NSW Department of Planning and
Infrastructure

**GUJARAT NRE NO.1 COLLIERY MAJOR
EXPANSION PROJECT PART 3A
APPLICATION**

Preferred Project Groundwater Assessment

20 December 2013

Figure 1. Comparison of previous and current mine plans for Wonga East. Current mine plan sourced from Gujarat (2013) and overlaid with georeferenced information from Coffey (2013). Comparison of Panel Layouts for Wonga East.

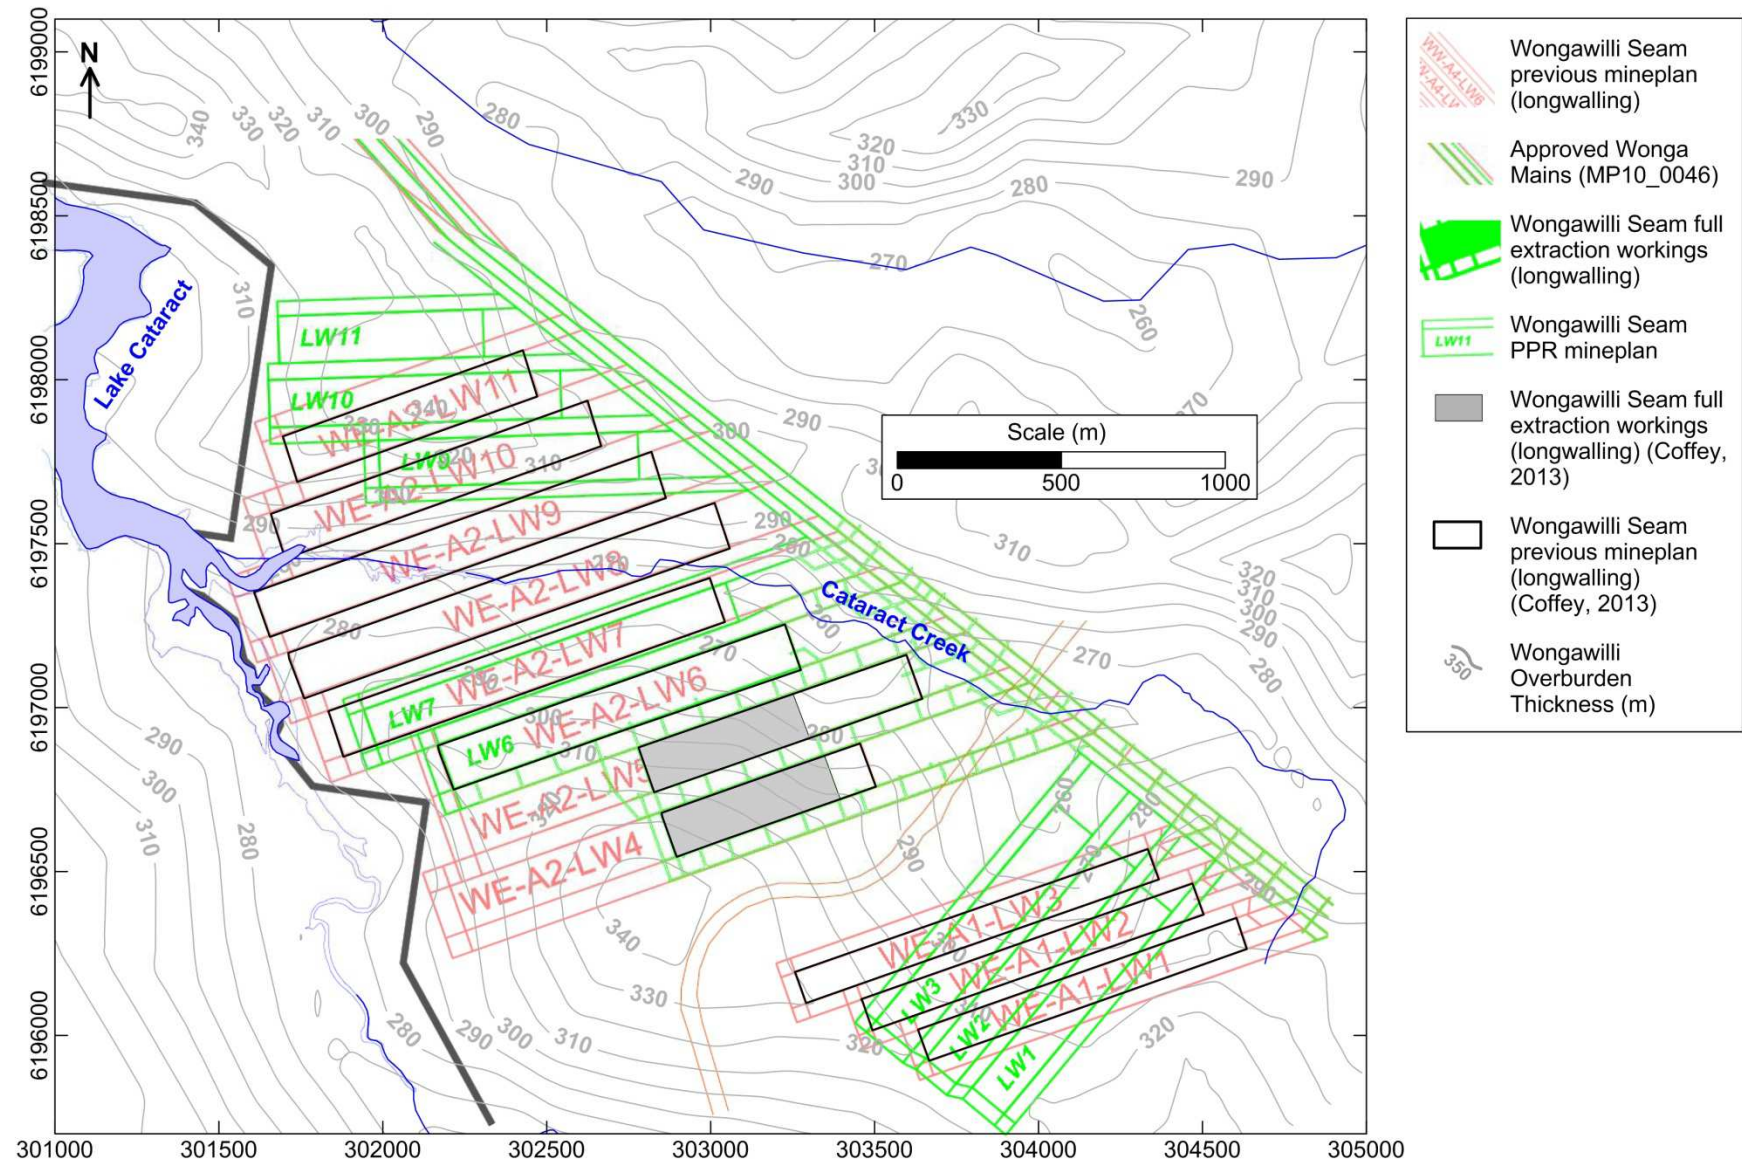
The new mine plan is presented in Figure 4 of the PPR however no scale is shown and it is not georeferenced. This mine plan was positioned with respect to the MGA by overlaying the EA and PPR mine plans of Figure 4 of the PPR onto a georeferenced drawing of the EA mine plan, and scaling it until a visual match was obtained between the two versions of the EA mine plan. The result is shown in Figure 1. This process allowed positioning of Cataract Creek (not shown in Figure 4 of the PPR) with respect to LW7 of the PPR mine plan. However, the positioning error from this process is unknown.

Based on the new mine plane, the PPR states that there is an interpreted risk of significant secondary impact to swamps BCUS4 and CCUS4.

Figure 2. Subsidence monitoring results for the (a) Balgownie and (b) Wongawilli panels at Wonga East (after Figures 49 and 58 of the PPR).

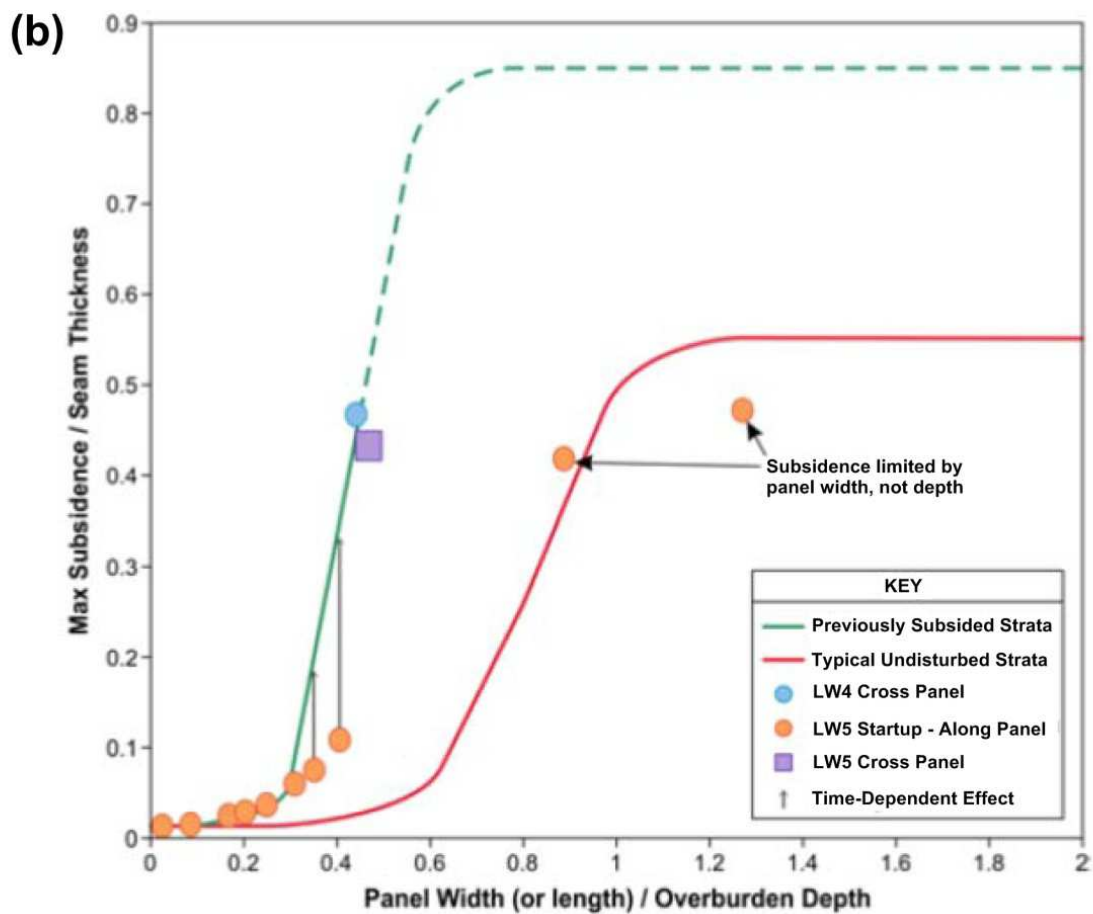
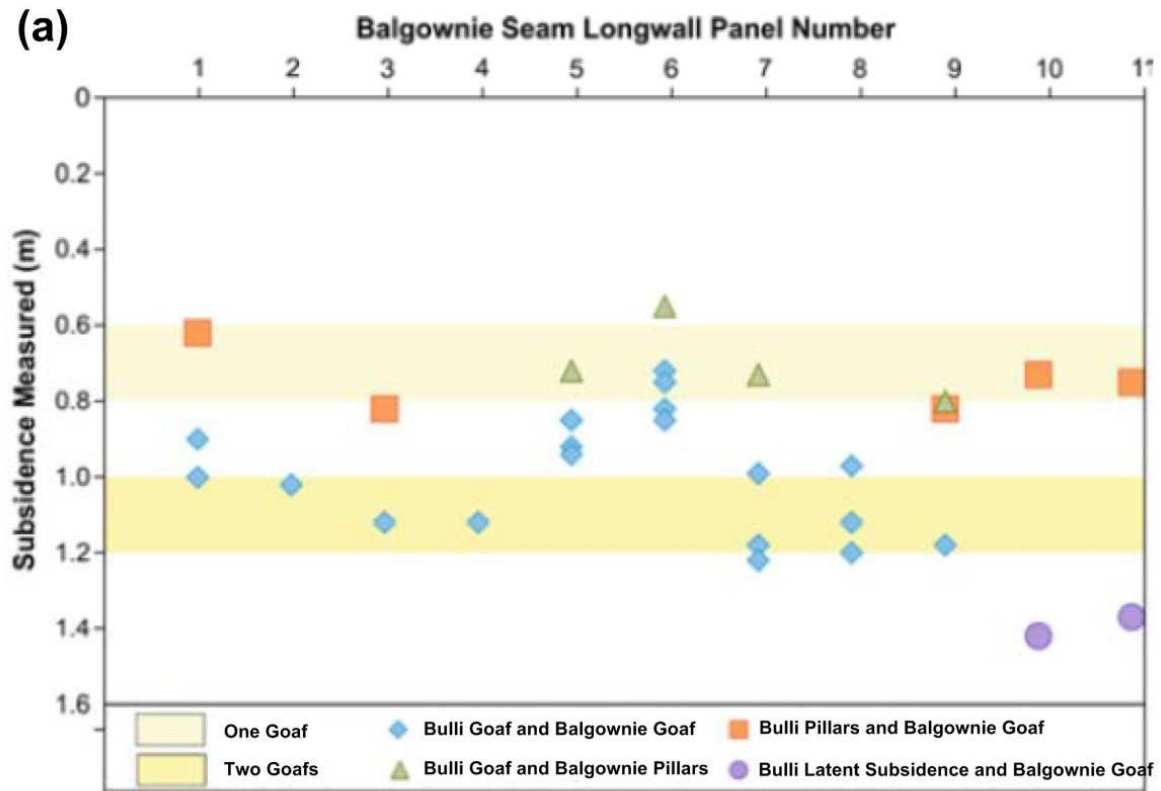
Subsidence measurements over existing total extraction workings in the Wongawilli East area are presented in detail in the PPR. These measurements are important as an indicator for the subsidence behaviour in a multiple seam mining environment. Subsidence monitoring of Balgownie and Wongawilli Seam panels in Wonga East indicates that incremental Balgownie panel subsidence ranged between 0.9m and 1.2m where overlying Bulli goaf (room and pillar panels with pillar extraction) was present, approaching 80% of the mined height (implying a mined height of about 1.5m for the Balgownie panels). In unusual areas (latent subsidence, goaf edge), the incremental subsidence reached 1.4m, approaching 100% of the mined height. Figure 2a (after Figure 49 of the PPR) shows these results.

Maximum incremental subsidence at Wongawilli LW4 was 1.4m. For the mining geometry of LW4, and assuming single seam mining, surface subsidence would be expected to range between 0.1m and 0.3m, about 14% of the observed subsidence where Balgownie and Bulli goafs are present. The PPR states that cross panel subsidence profiles indicate that the maximum subsidence in the centre of the Wongawilli panels is controlled by overburden bridging capacity rather than strata recompression. The presence of overlying goafs reduces the bridging capacity of overlying strata, having a significant effect on maximum incremental subsidence for the Wongawilli panels. It was also observed that the additional subsidence was confined to the panel footprint. Figure 2b (after Figure 58 of the PPR) shows these results.

Surface subsidence results presented in the PPR indicate that the accrued surface subsidence from multiple seam operations is more than an addition of estimated single seam subsidences. Although a relationship between surface subsidence and the height of desaturation (H) is unavailable (due to the significantly greater dependence of surface subsidence on overburden depth compared to H), the surface subsidence results would suggest that the accrued height of the collapsed zone for multiple seam operations also may be more than an addition of estimated single-seam H values (Tammetta, 2012). If this is the case, the consequence is that, where a Wongawilli panel underlies existing full extraction workings, the height of H for the Wongawilli panel will be larger than that calculated using the relationship for single seam mining (Tammetta, 2012).

Figure 4. VWP hydrographs for Monitoring Location GW1 (see Coffey, 2013).

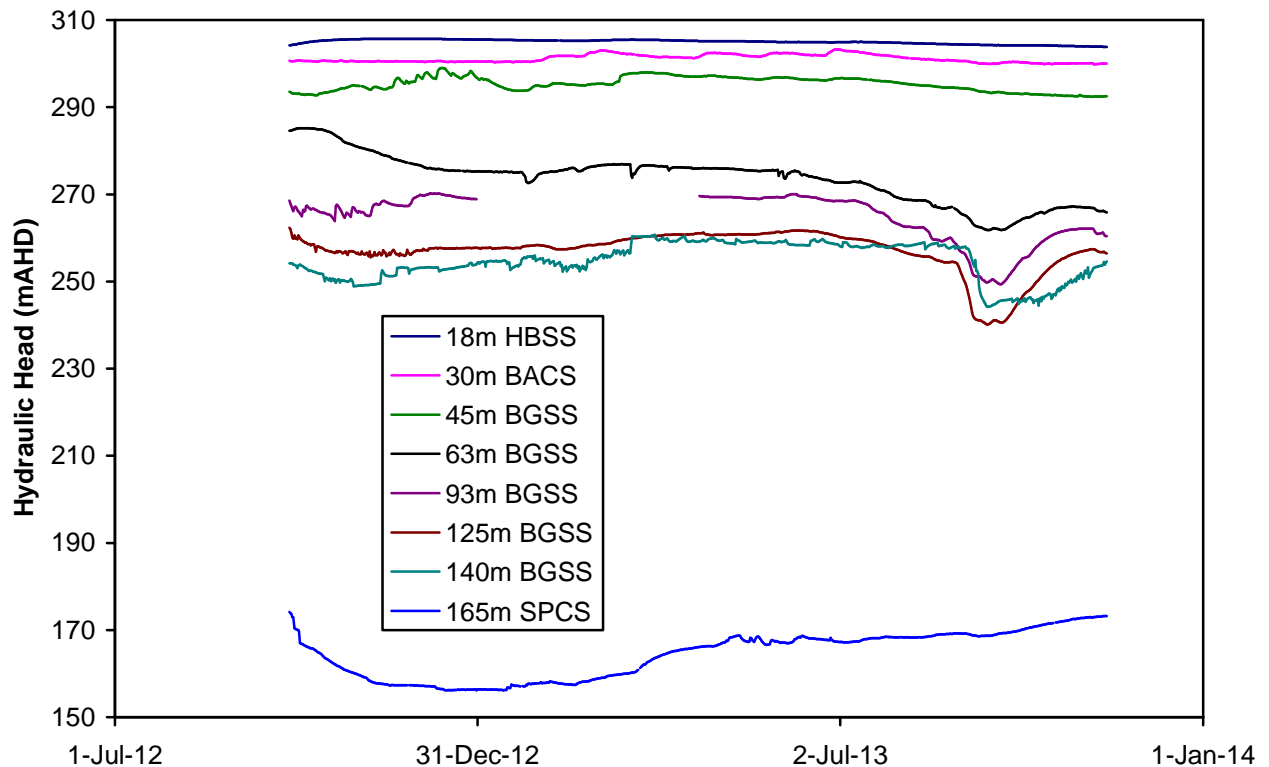
Hydraulic head monitoring data from the vibrating wire piezometer (VWP) nest at GW1 (see Coffey, 2013) were selected by the proponent for collection of near-field drawdown from longwall advance, for the purpose of model calibration. The monitoring data were not presented in the PPR but were supplied by Gujarat by email on 19 November 2013, at the request of the reviewer. Figure 5 shows the supplied data. The key in Figure 5 shows the depth below ground for each VWP, and the lithology at that depth (HBSS, BACS, BGSS, and SPCS denote the Hawkesbury Sandstone, Bald Hill Claystone, Bulgo Sandstone, and Stanwell Park Claystone respectively). The hydrographs for Bulgo Sandstone VWPs capture the effect of depressurisation from LW5 in late 2012. The measured drawdown is considered useful for model calibration of near-field disturbance.
